BLACK FOREST

COL02037

**14755 BLACK FOREST ROAD
BLACK FOREST, CO 80908**

PARCEL PLAN

PARCEL PLAN

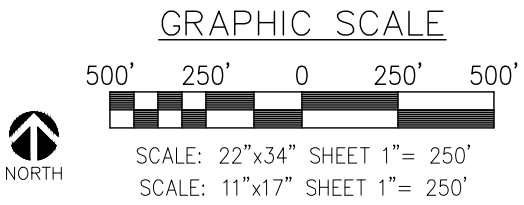
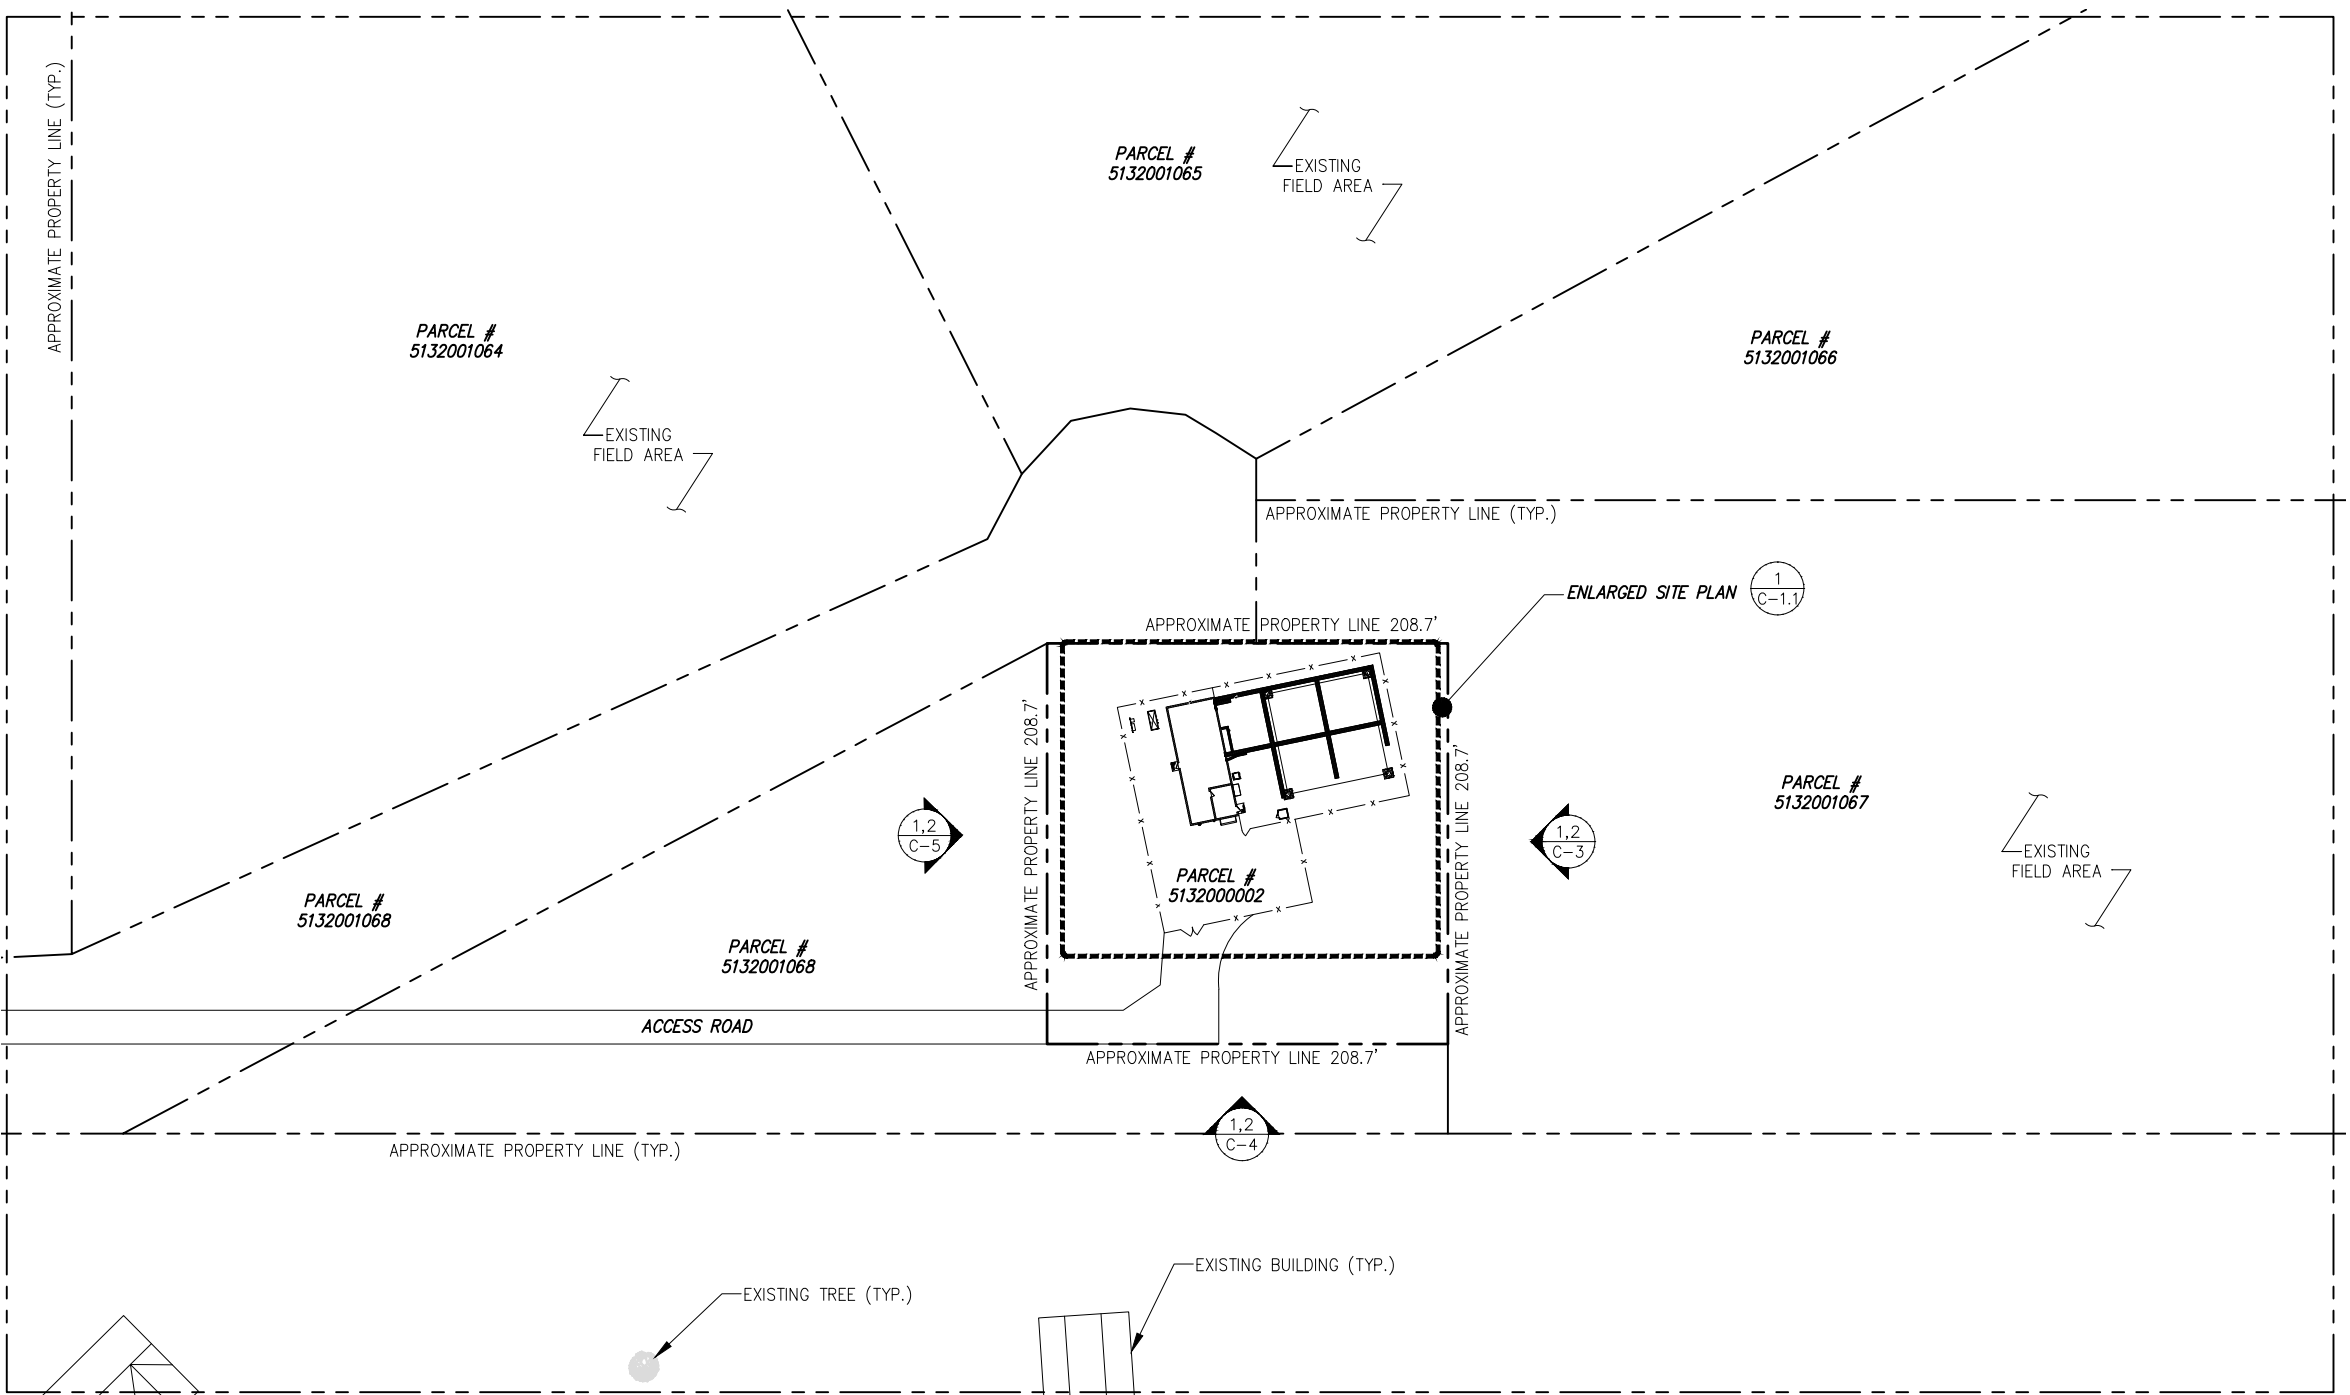
Vicinity map needs to provide more context to major roads. The only major road depicted here is Black Forest Rd. Please provide a new vicinity map with more context.

Please label this road.
